**Our Ref: FP/25/13/
Your Ref:**

**Town & Country Planning Act 1990 (as amended)
Town and Country Planning (Development Management Procedure) (England) Order 2010 (as amended)
Application for Planning Permission**

Development Demolition of existing dwelling and erection of new property together with a new single car parking space and carport/workshop in rear garden
Location Fleet Cottage The Ridgway Bognor Regis West Sussex

Site Plan

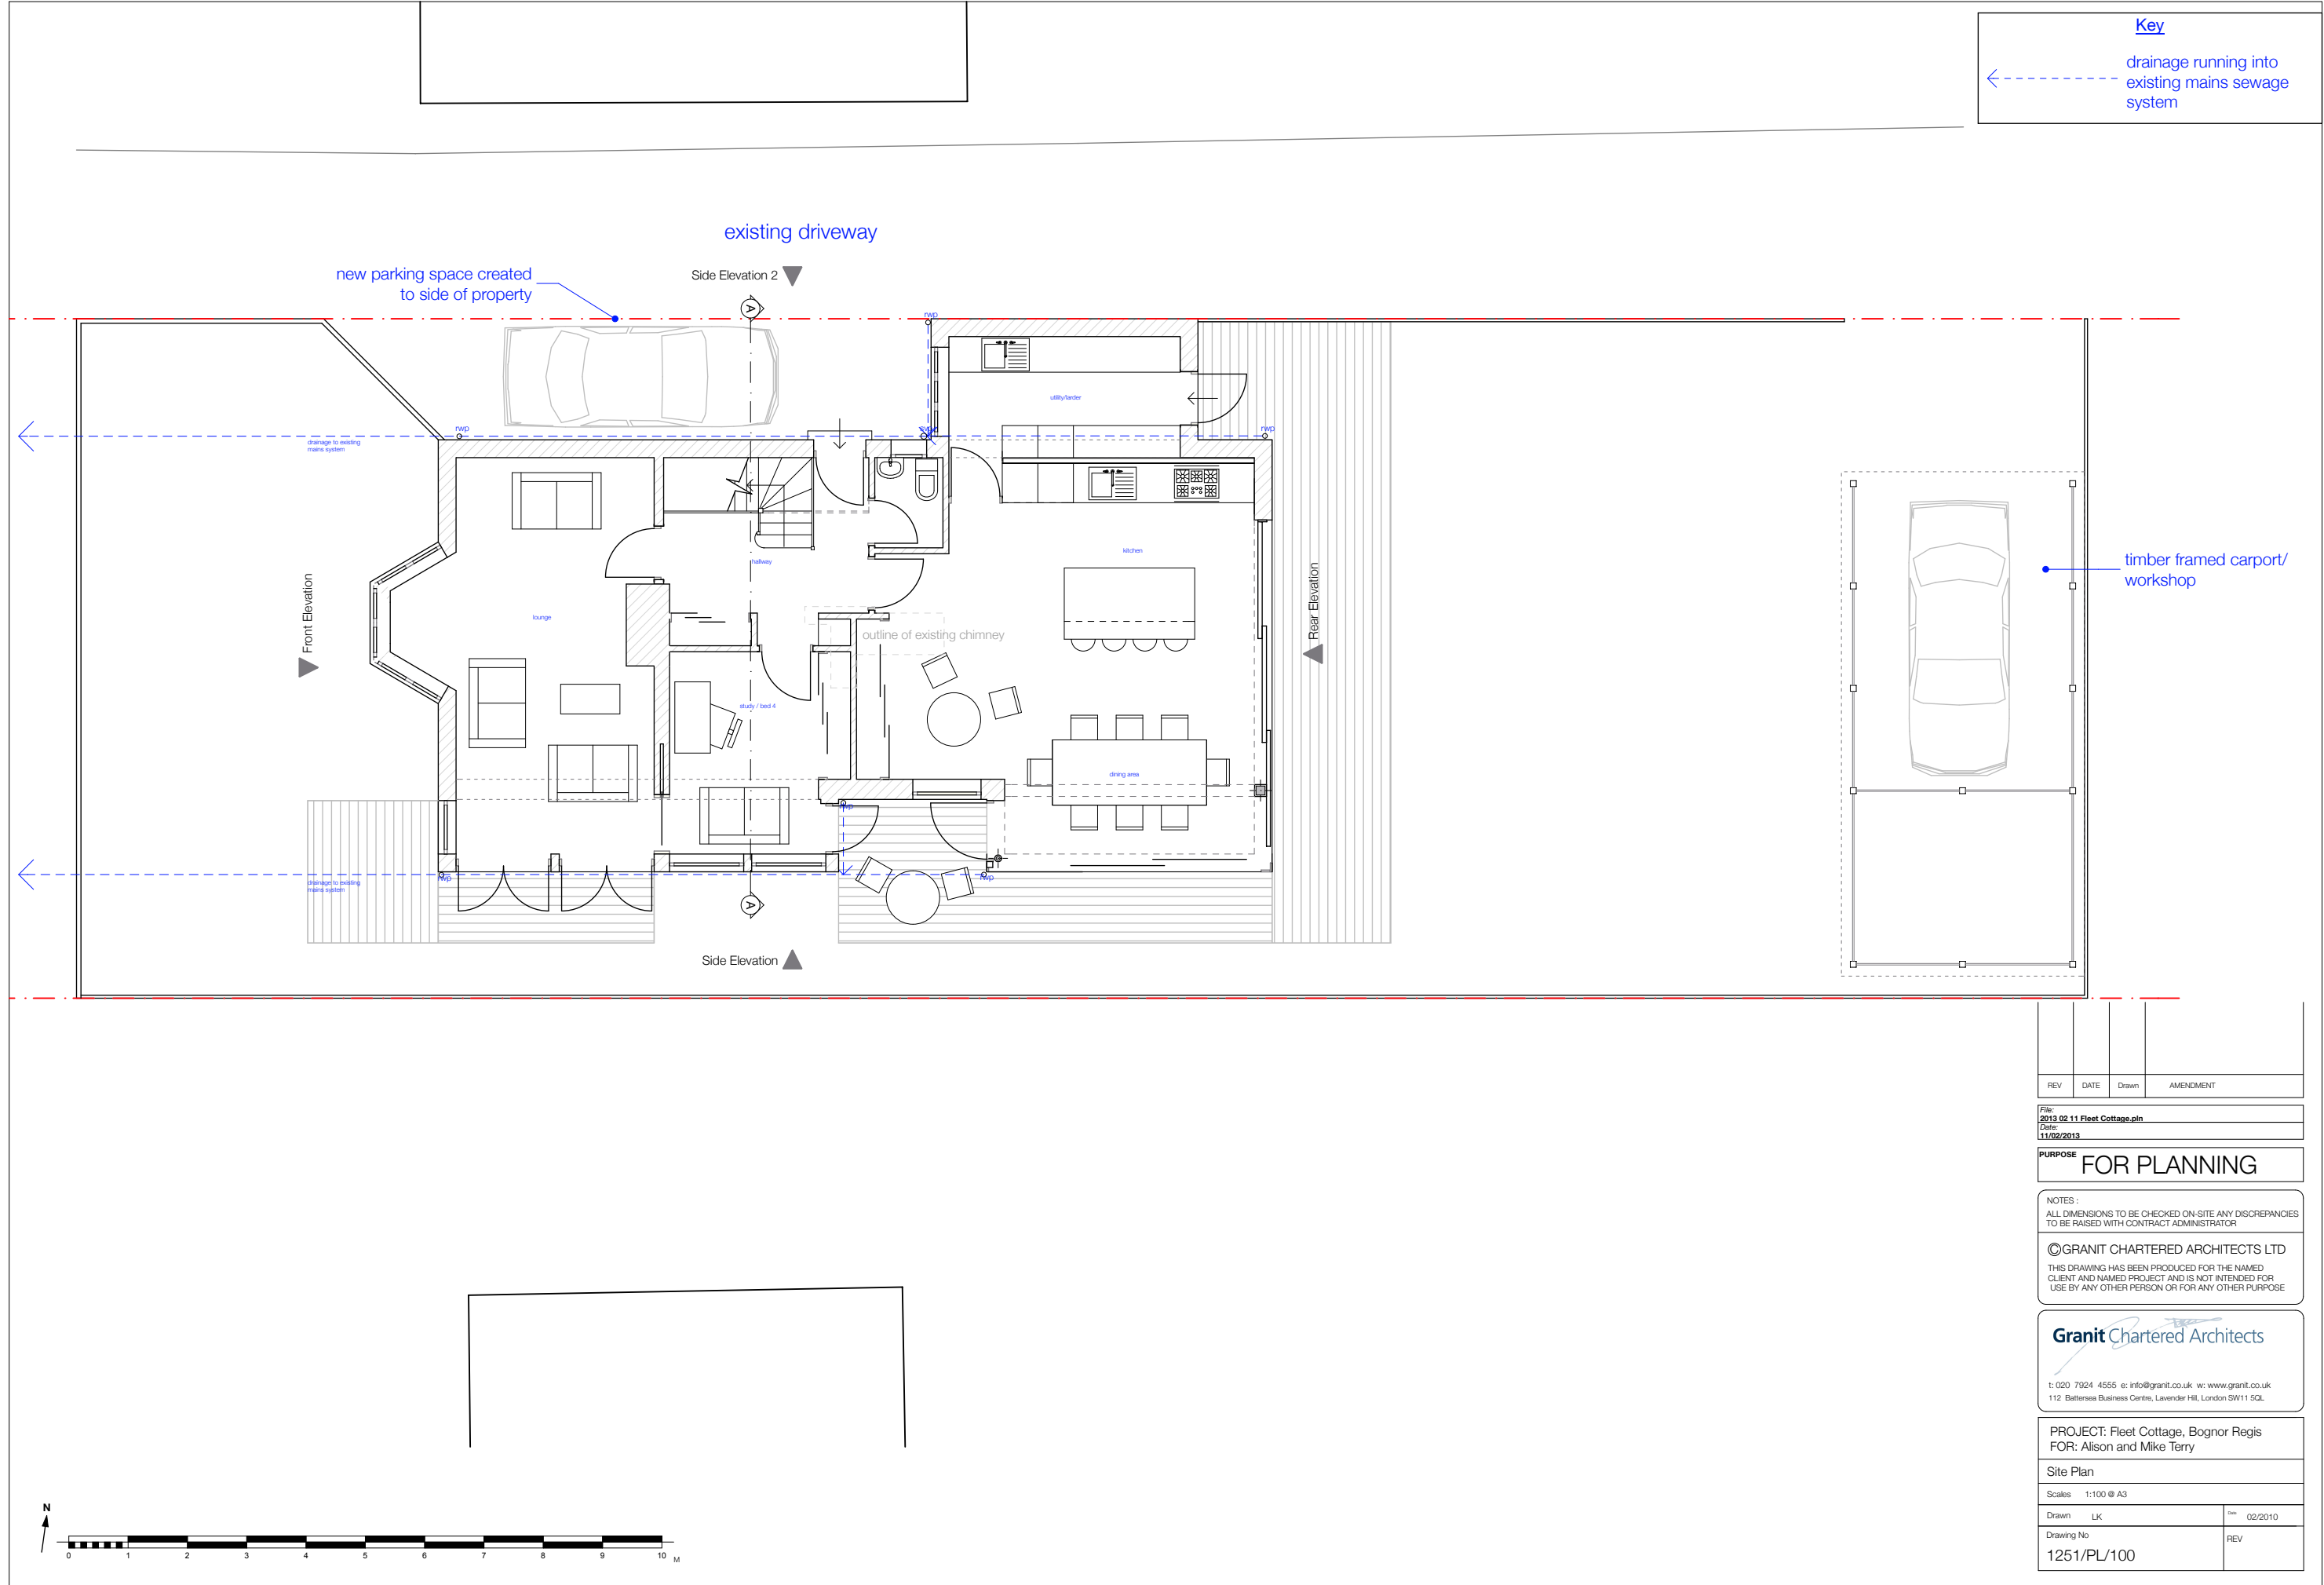
Please forward an amended block plan to show position of proposed dwelling, car port & parking space and footprint of dwelling to be demolished
